Application no: 23/03073/HYBRID

Location: Phase 2 SW Bicester Kingsmere Parcel R East Of, Ludlow Road, Bicester

Transport Schedule

Recommendation: Objection

Table 3.2: Proposed Pedestrian Connection

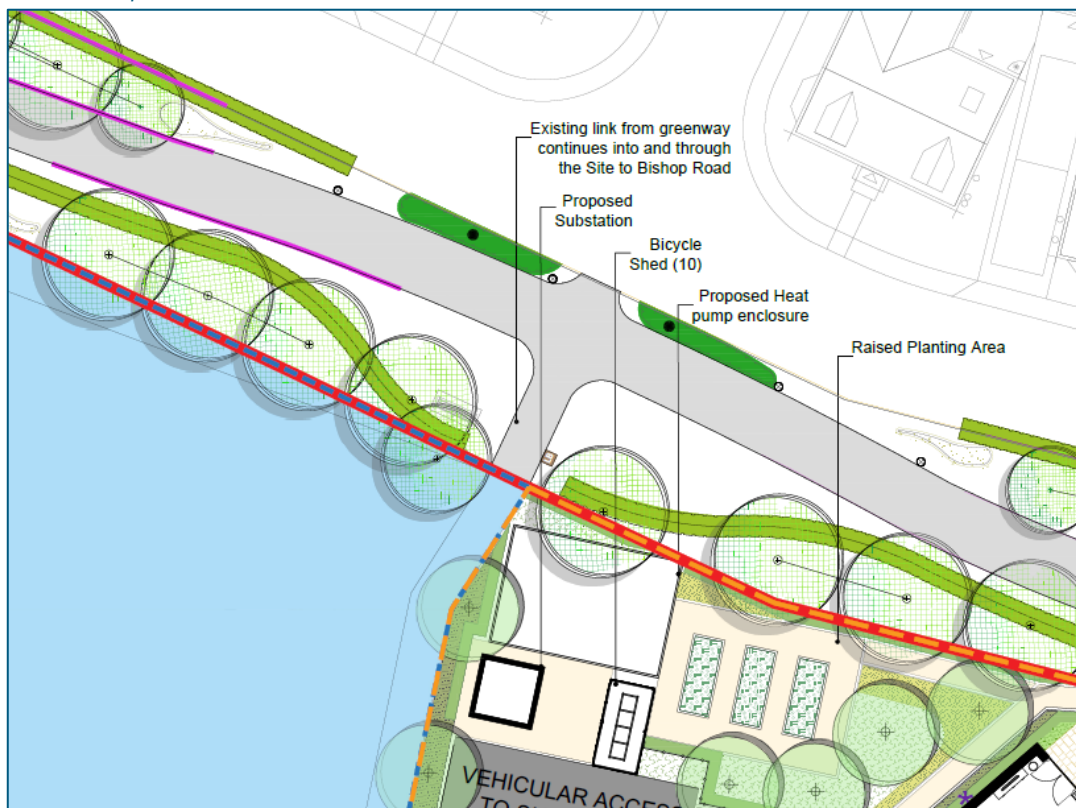
- Paragraph 2.2.2 – discusses ‘good quality pedestrian infrastructure’. What pedestrian infrastructure is available on site? Dropped Kerbs, crossing points, tactiles etc?
